Ribble Valley Borough Council

App No: 3.2025.1006

Location: Land off Pendle Road Clitheroe

Proposal: Outline application for the erection of up to 200 dwellings and associated landscaping, childrens play area, sustainable urban drainage and other infrastructure with all matters reserved except access.

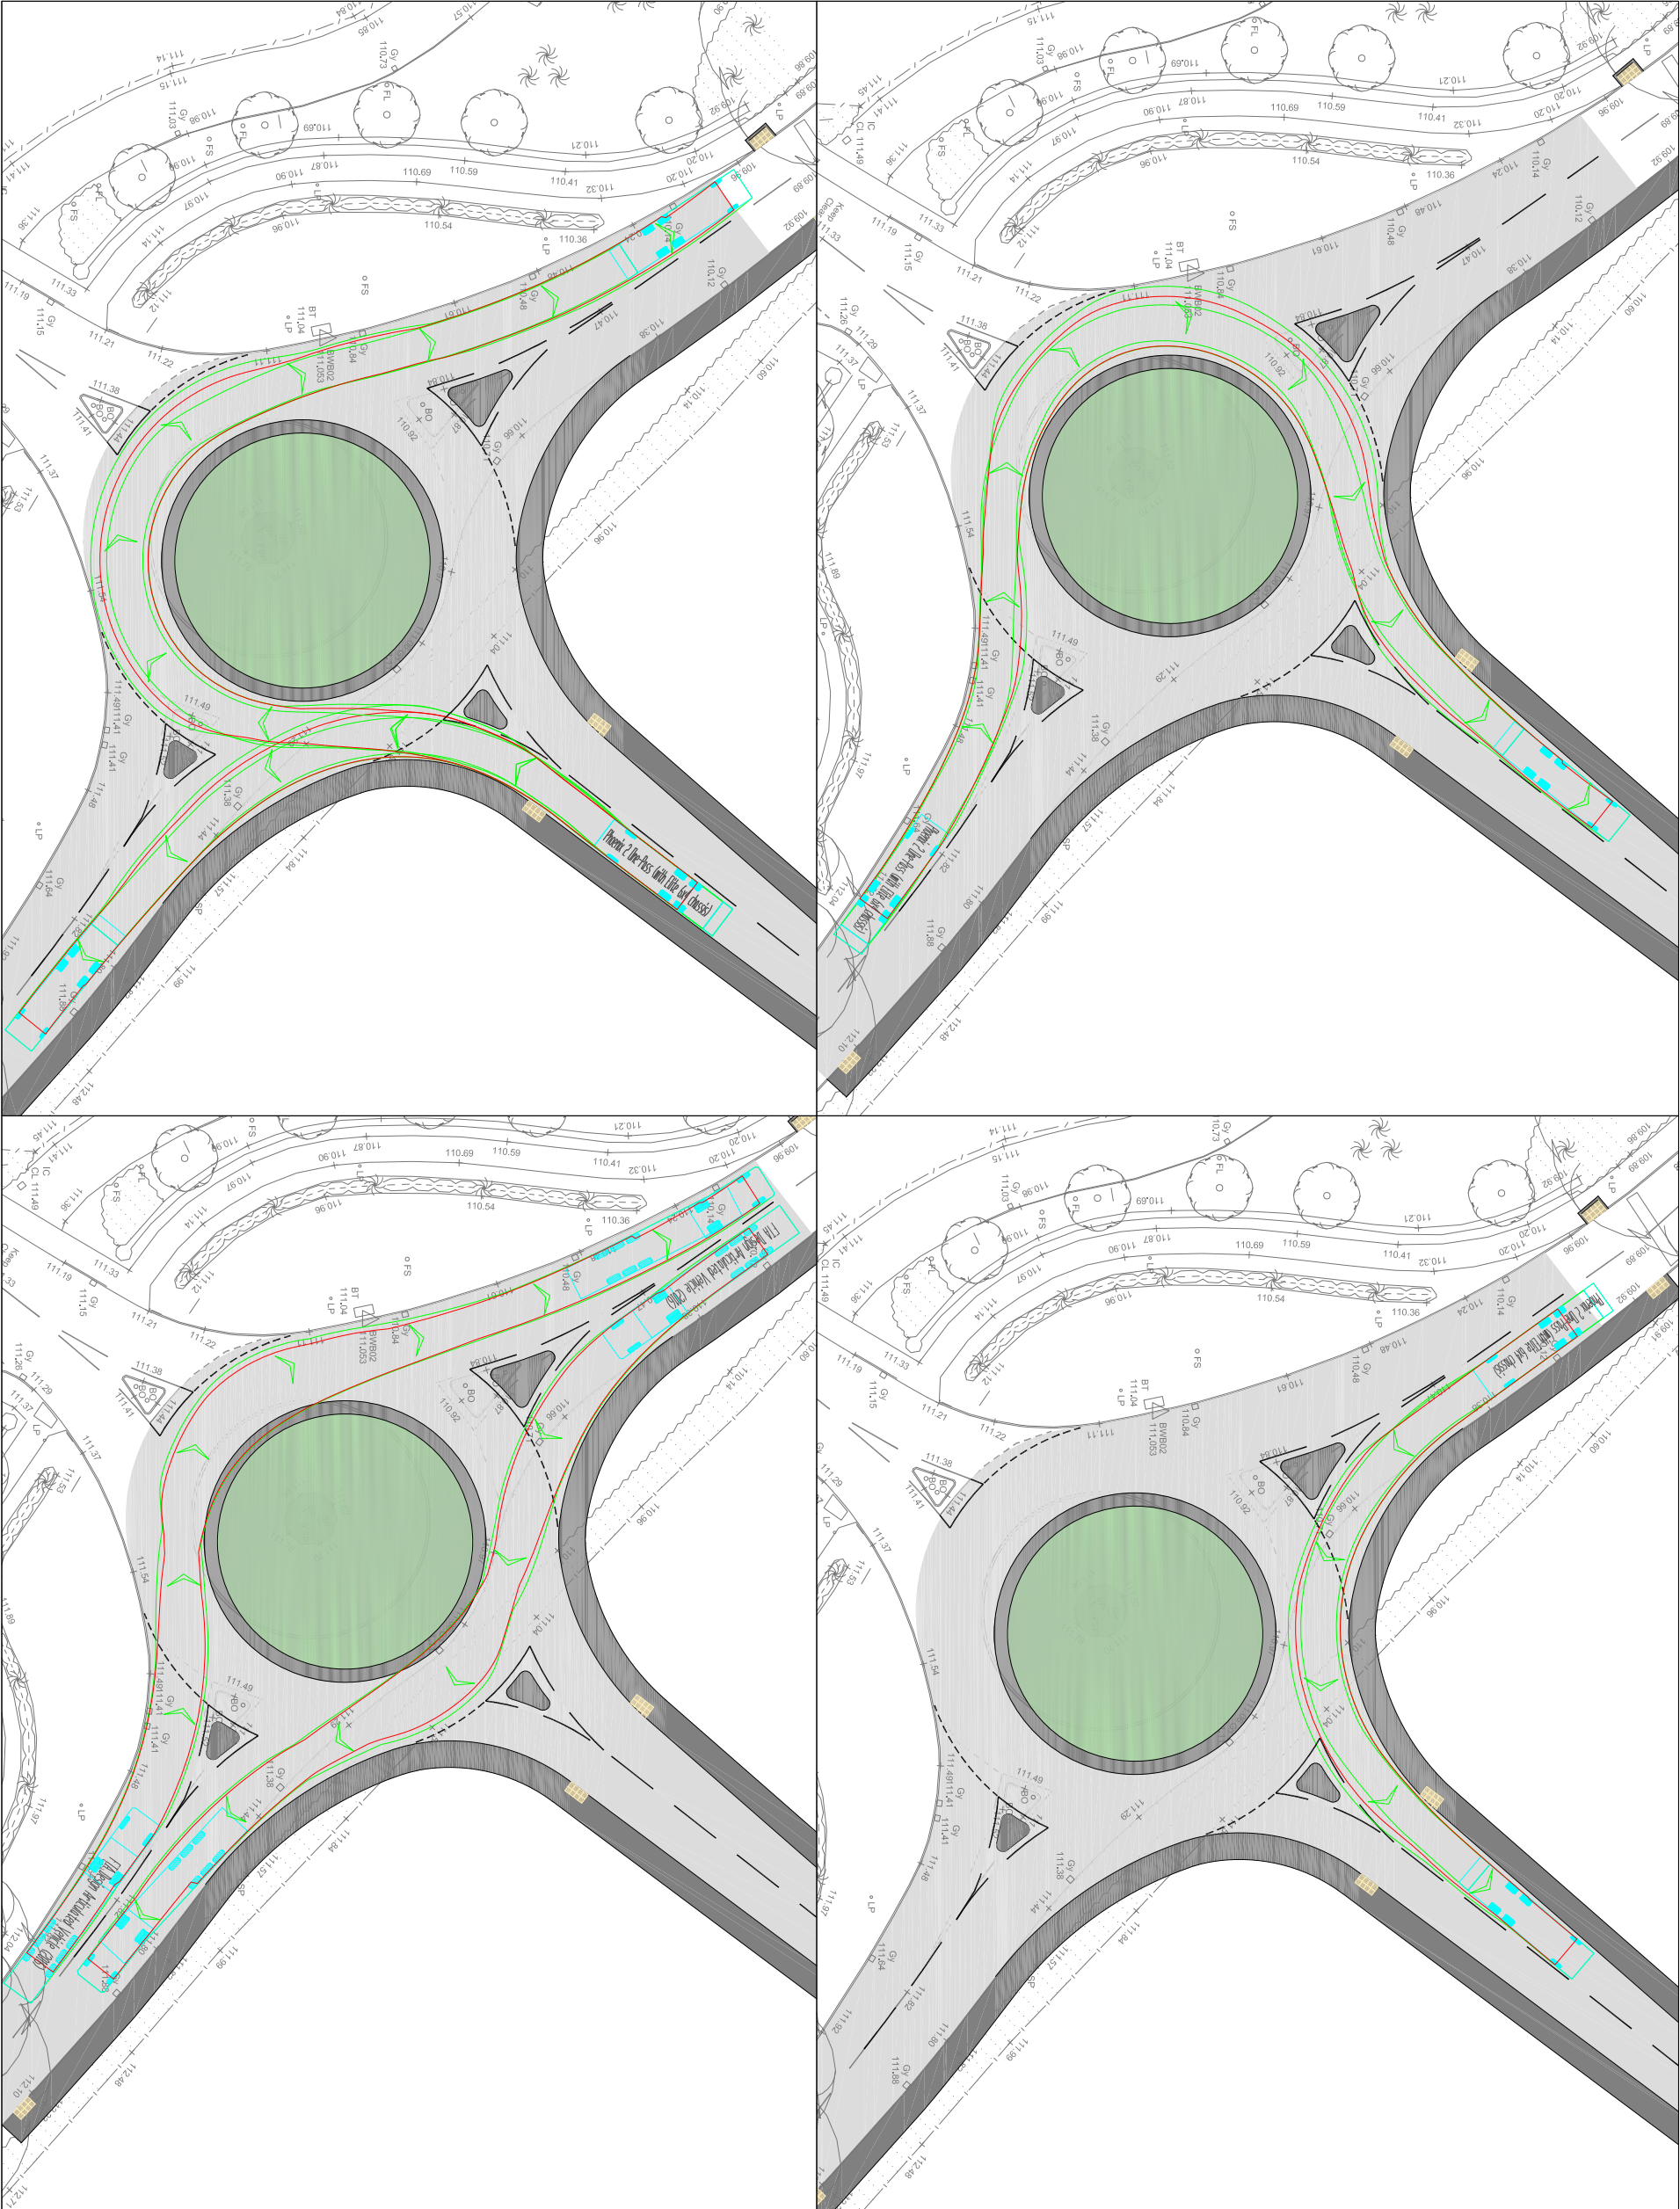
Pendle Road C553 is subject to a 40mph speed limit. A new 4th arm will be created on the roundabout at Pendle Road/Higher Standen Drive with an increase of ICD to 32m providing a compact roundabout to DMRB CD116. A checklist is provided to CD116, we have requested a more detailed form.

Tracking is provided for 16.48m long articulated vehicle and 11.18 refuse vehicle.

Pedestrian crossing infrastructure across the central island on Pendle Road at the southeastern arm of the roundabout is proposed.

The new footway to the northwest and southeast sides of the roundabout is widened to 3.5m to provide a shared cycle/footway.
